Application for a non-material amendment following a grant of planning permission.

Number	2
Suffix	
Property name	Thomas A Beckett Cottage
Address line 1	Pagham Road
Address line 2	
Address line 3	
Town/city	Pagham
Postcode	PO21 4NP
Description of site location must be completed if postcode is not known:	
Easting (x)	488642
Northing (y)	97569
Description

Extension of the existing dwelling to provide first floor accommodation.

P/99/18/HH

Title:
PROPOSED GROUND FLOOR PLAN

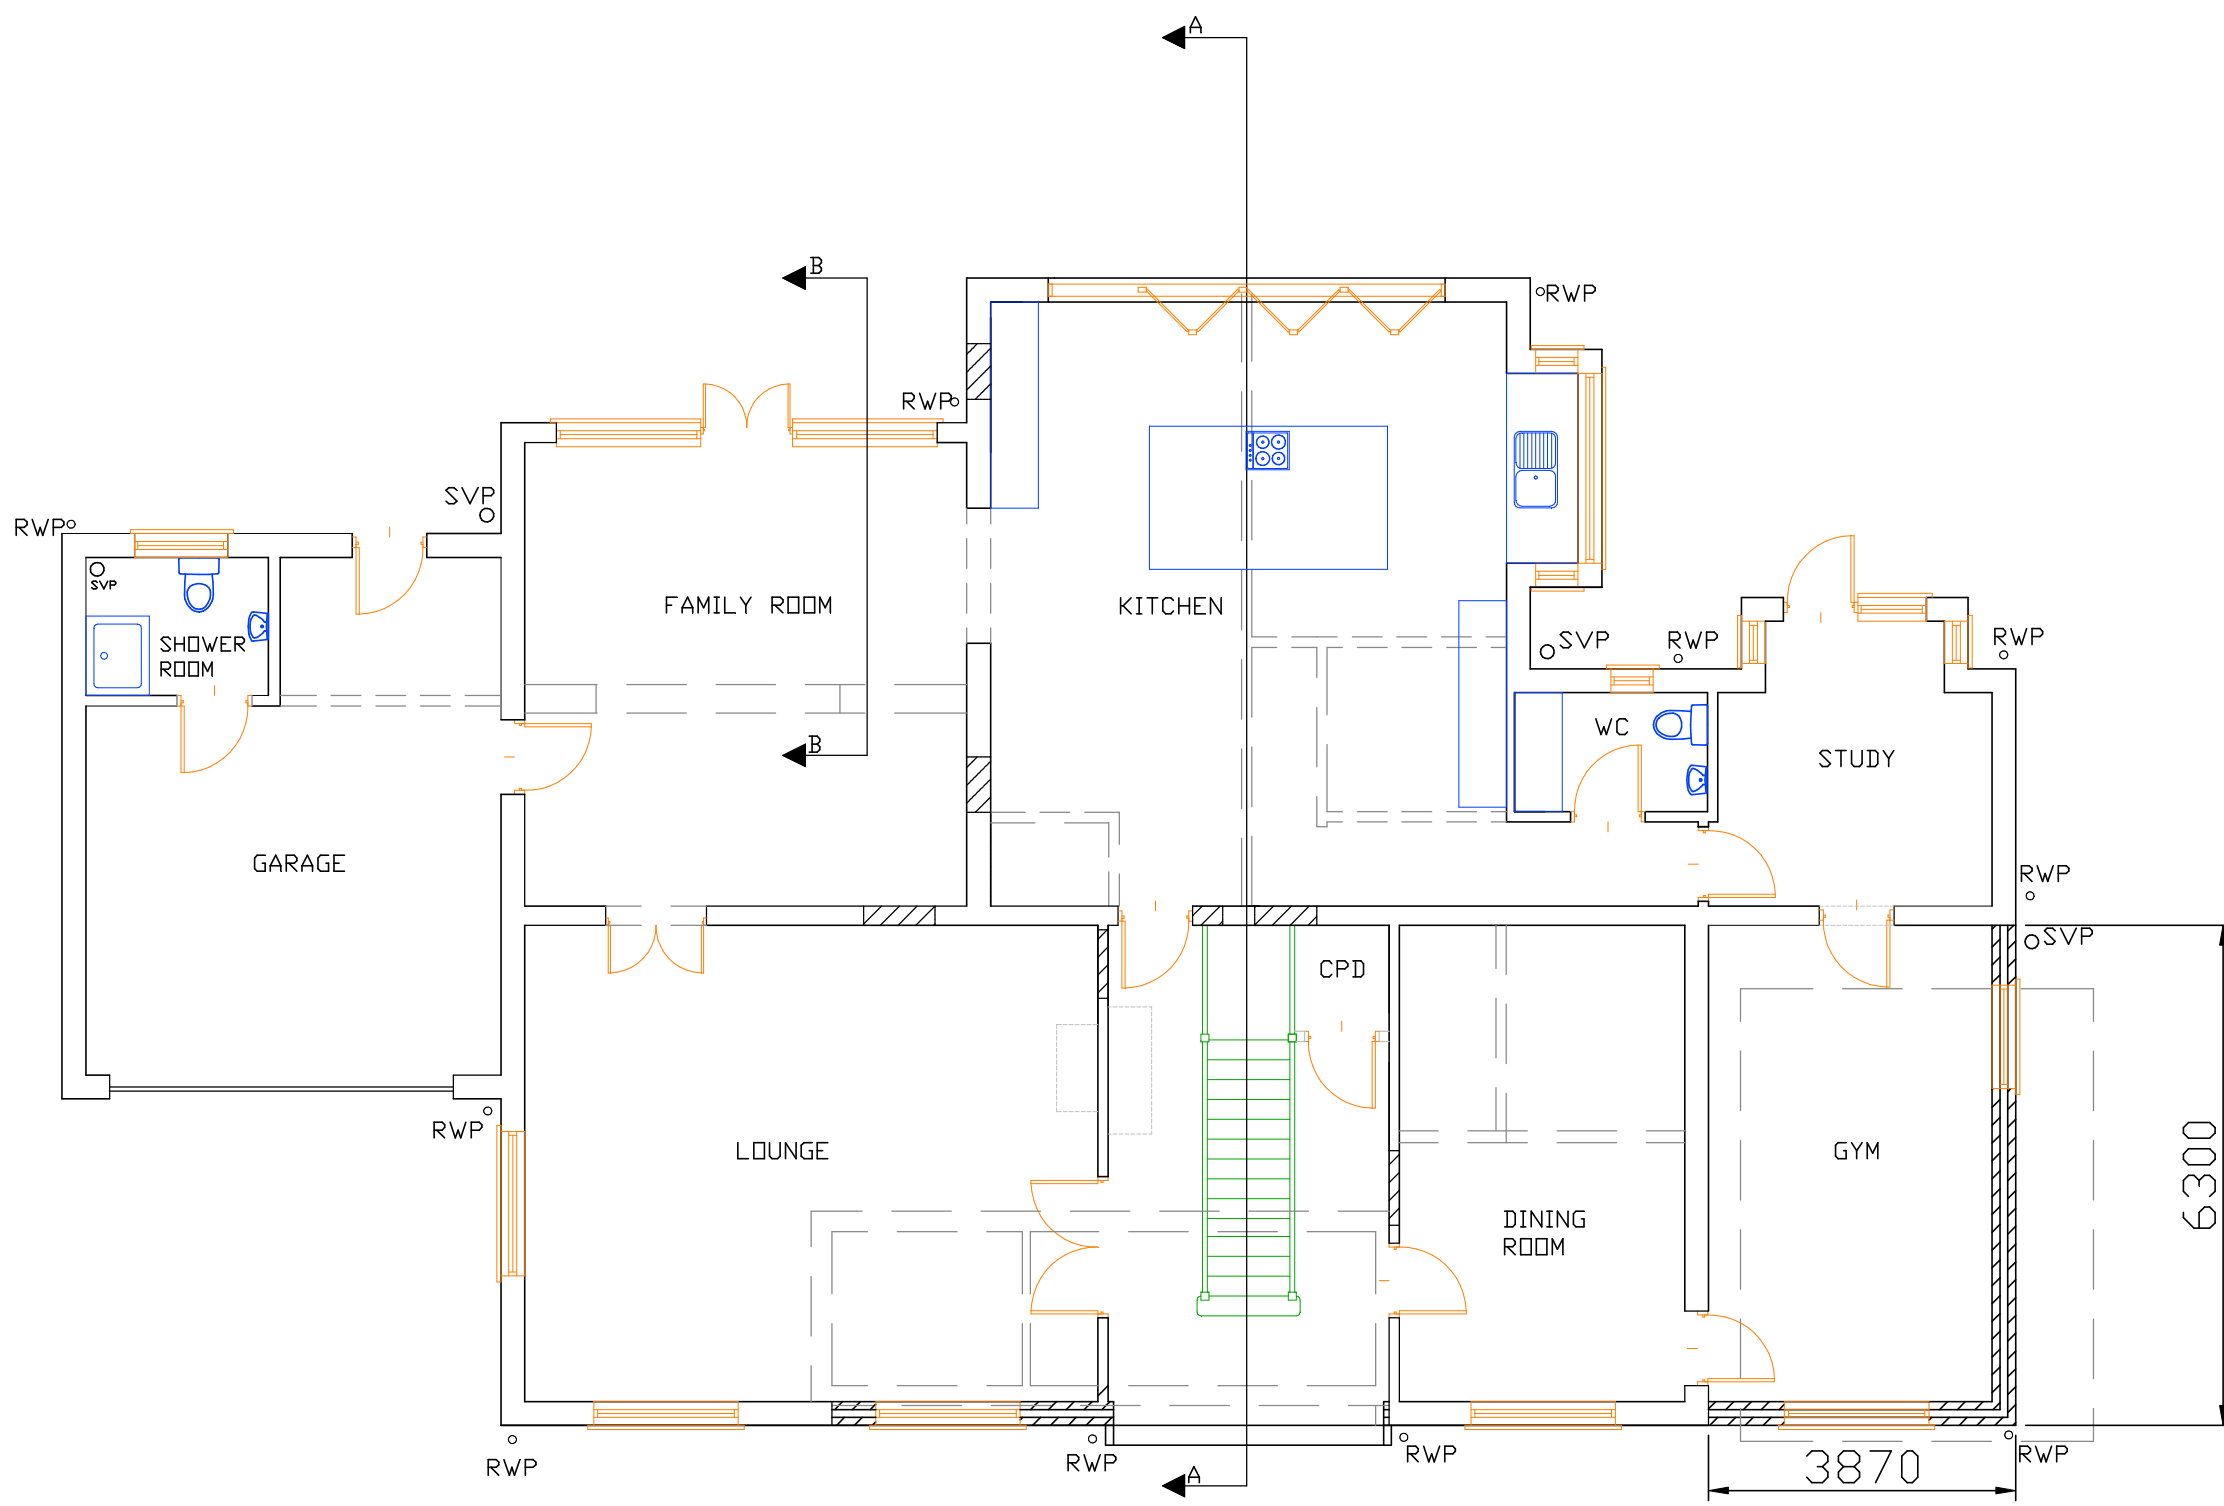
Remove the pool house section
Provision of support posts to the front porch / balcony
Replacement of kitchen external doors and windows with bi-fold doors
Deletion of utility and music room
Amendment of wall position between en-suite shower-room and closet in 2 bedrooms
Amendment of roof angle on North and South elevations such that matching East and West elevations

Remove the pool house section - in order to reduce the impact of built structures within the property and surface water management associated.
Provision of support posts to the front porch / balcony - in order to provide simpler mechanical loading to ground vs previous cantilever design.
Replacement of kitchen external doors and windows with bi-fold doors - to increase the natural light transmission into the property and for improved layout in the kitchen.
Deletion of utility and music room - Preferred usage of space.
Amendment of wall position between en-suite shower-room and closet in 2 bedrooms - Preferred layout of space.
Amendment of roof angle on North and South elevations such that matching East and West elevations - Optimised to match all elevations and improve roof construction.
